Your Ref: OWPC7118
Our Ref: LU/261/15/HH 12-08-2015
Please ask for:
Mr D Easton

Single storey rear extension, alterations to windows facing South to form bifolding doors, replacement of North facing windows, change second floor windows to form bifolding door, addition of Juliet balcony, addition of 4 No. rooflights & extension of external decking at front. This application may be determined by Littlehampton Town Council under delegated powers.

10 Mariners Quay River Road Littlehampton

Thank you for your internet representation made on 12th October 2015 which has been recorded as '**an objection**' with the comments as follows:

REAR ELEVATION
1:30

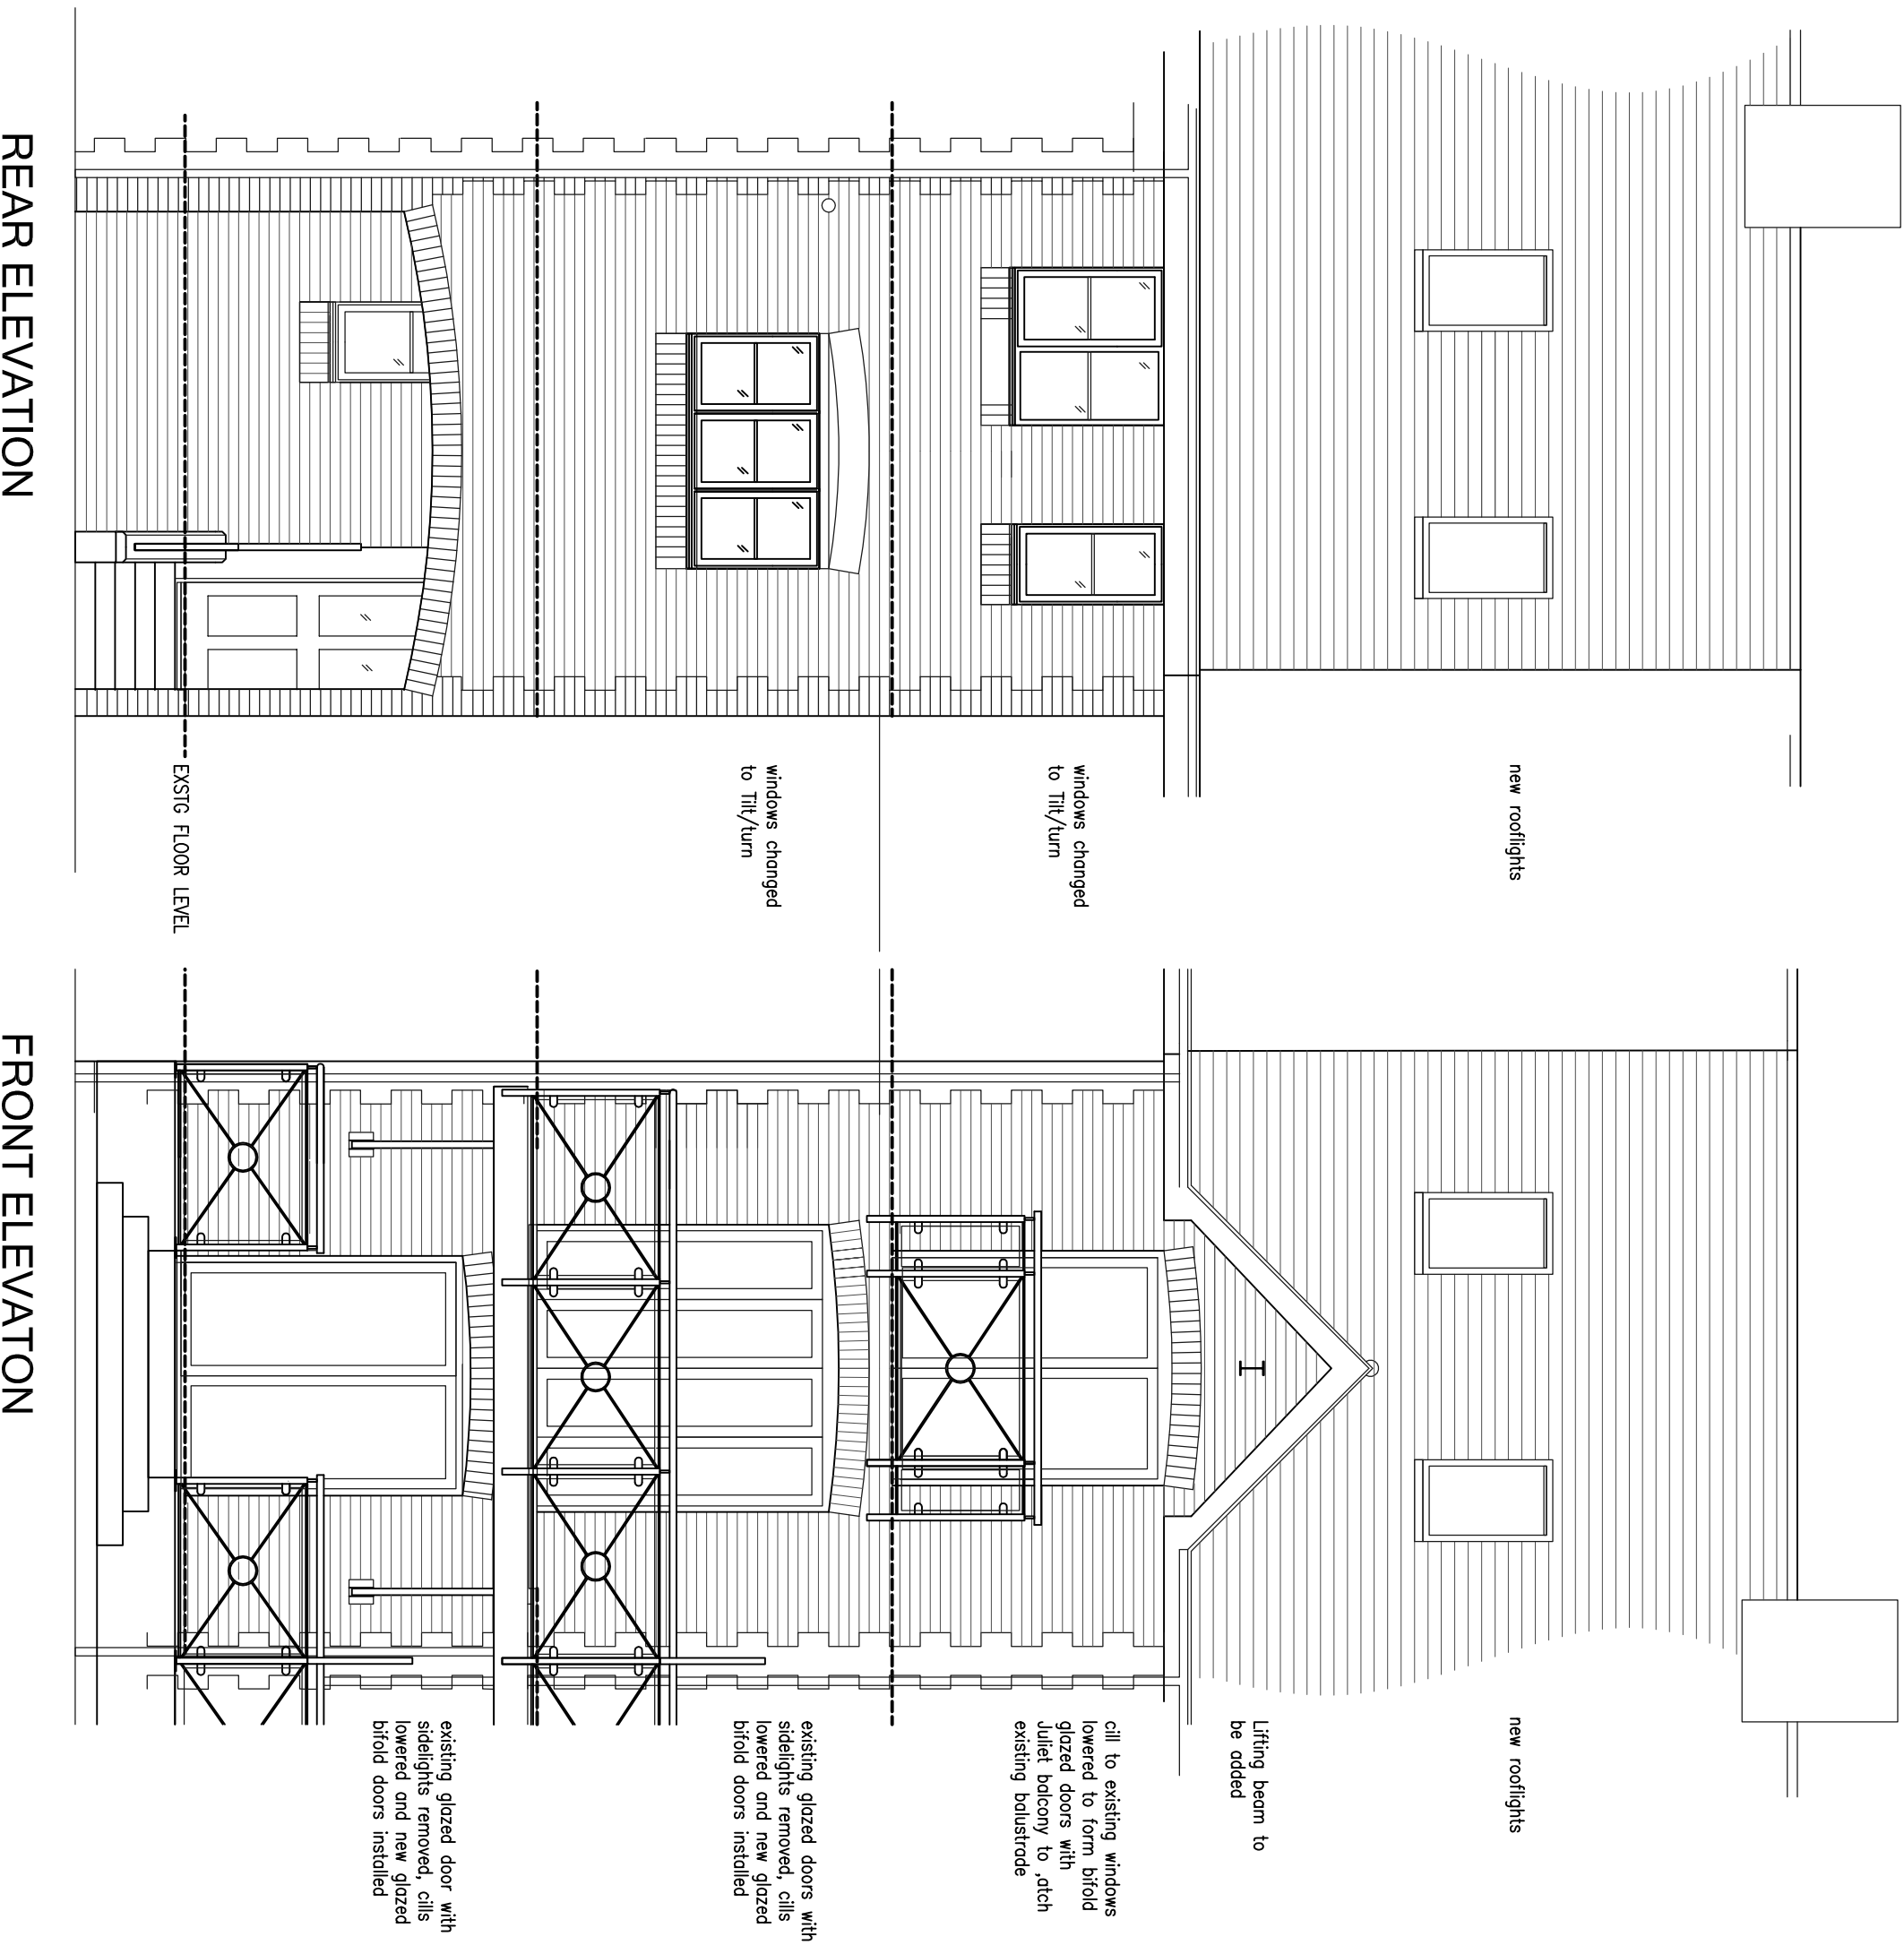
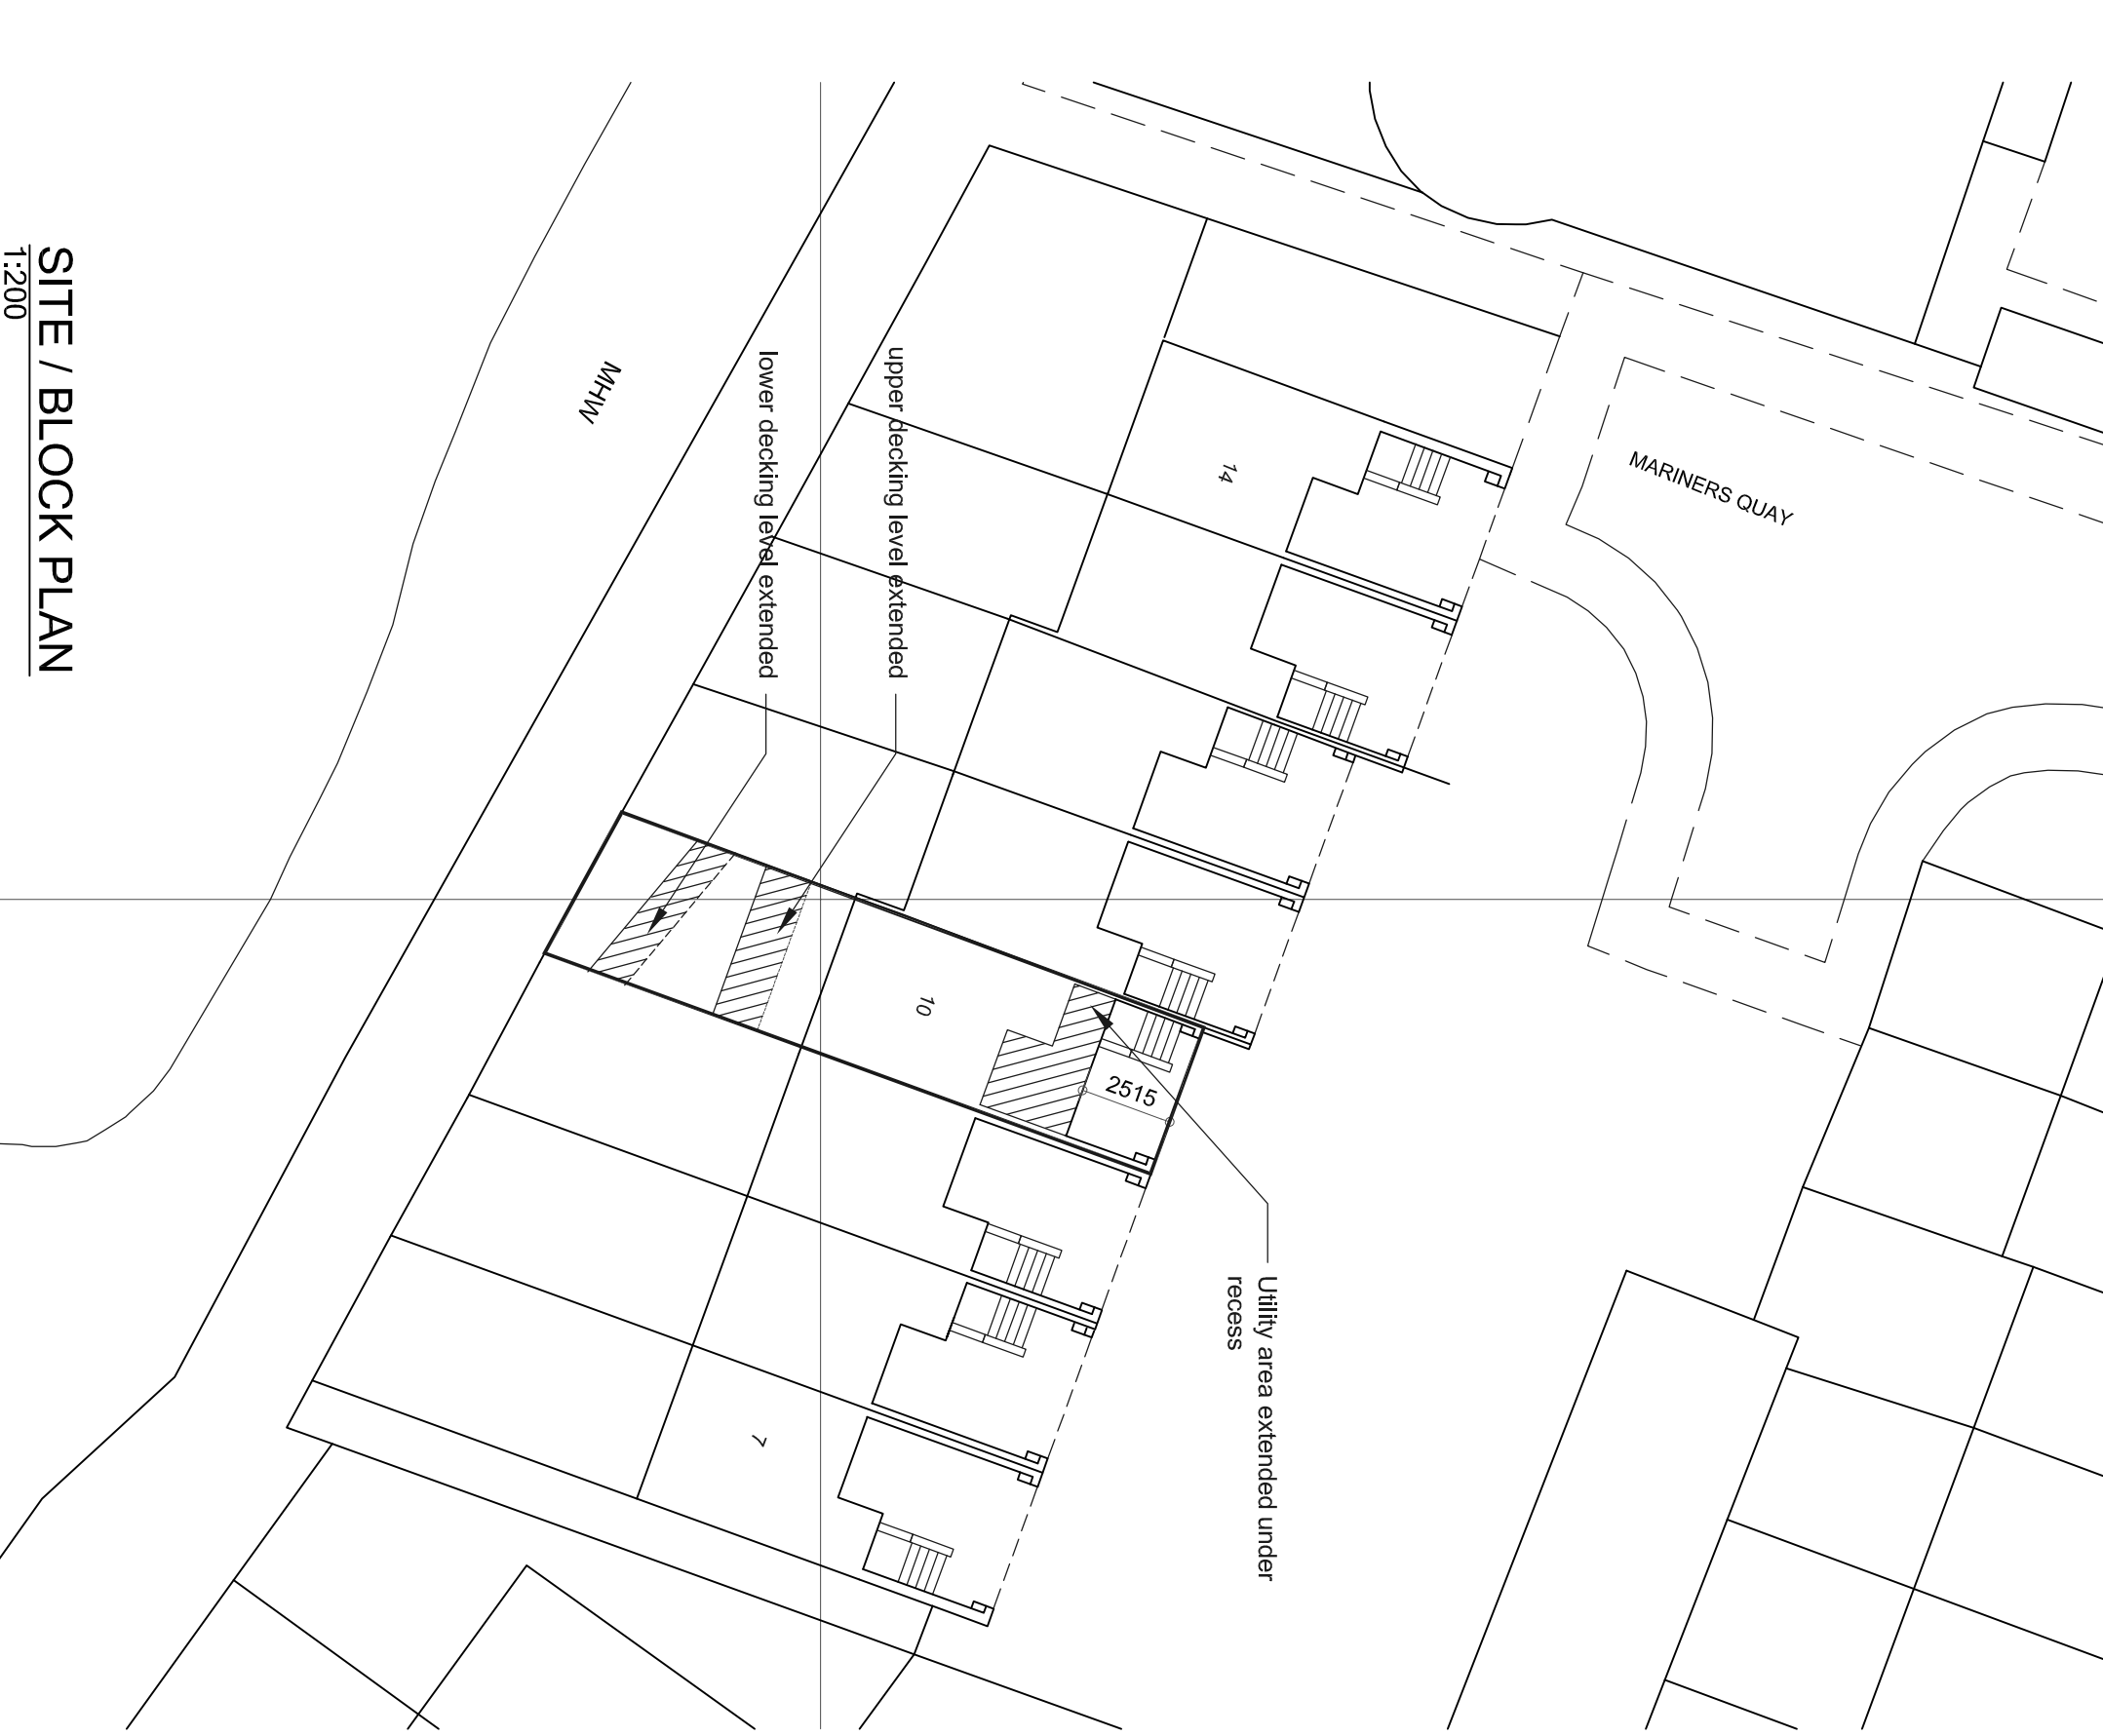
- 5) the unified look of this stretch of the River Arun will be spoiled by making number 10 look very different to its neighbours - the impact of the alterations to the windows and roof will not blend in with the rest of the houses ;*

SITE / BLOCK PLAN
1:200

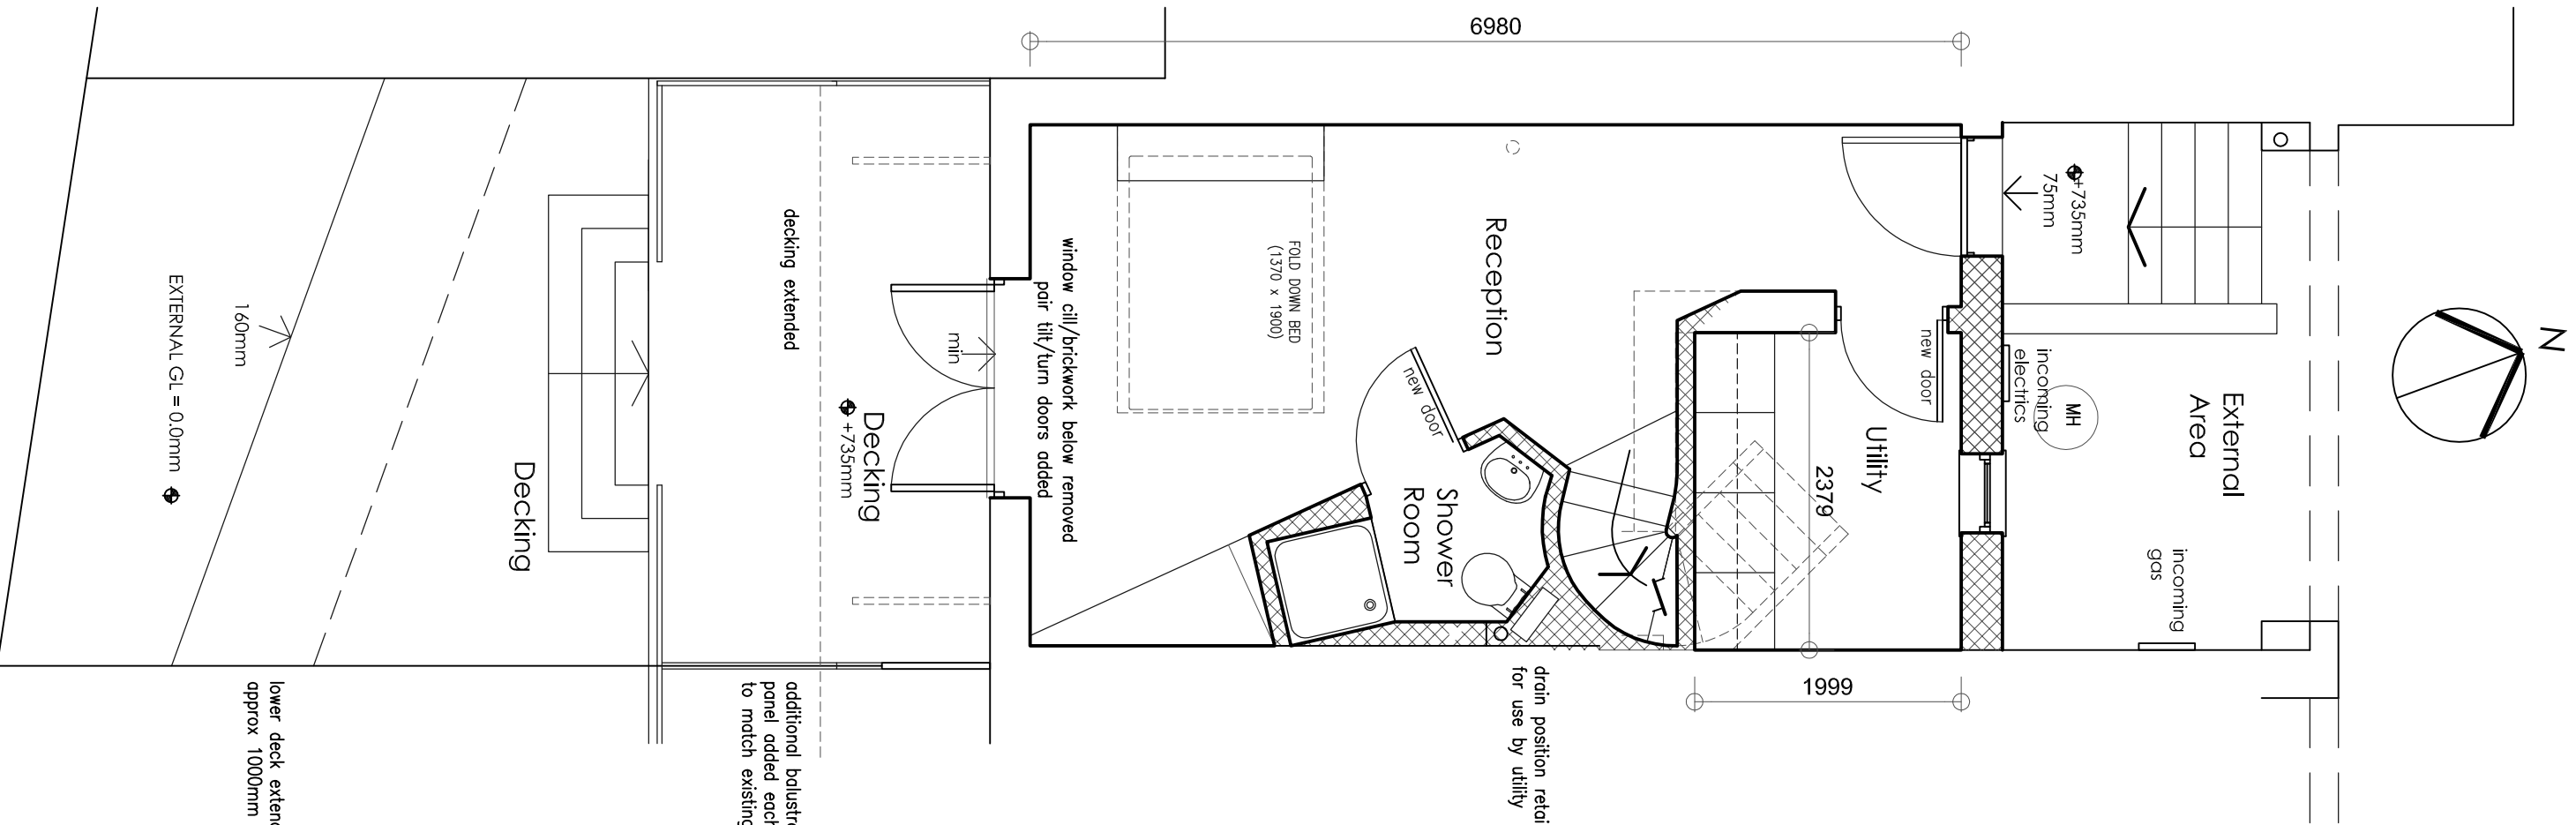
- 1) the extension of the decking towards the river will be an invasion of the privacy of others living nearby as set out in the objection sent on 6 October;*

- 4) the comment on page 5 of the Flood Risk Assessment attached to the application is incorrect as the plans show there is a permanent bed to be provided in the ground floor room and so the risk of flooding is at least as at present and I suggest greater if the built-up decking area is extended which again will affect neighbouring properties;*

- 2) the permanent loss of a parking space on the north side caused by the extension of the ground floor to make a utility room will increase congestion for neighbours and visitors including tradesmen - the area is already very congested as many occupants have 2 or more vehicles;*

- 3) this loss of a parking space will also increase the disturbance and disruption for the neighbours while the proposed work is carried out - there has already been considerable disturbance for several weeks and neighbours should not have their lives upset in this way;*
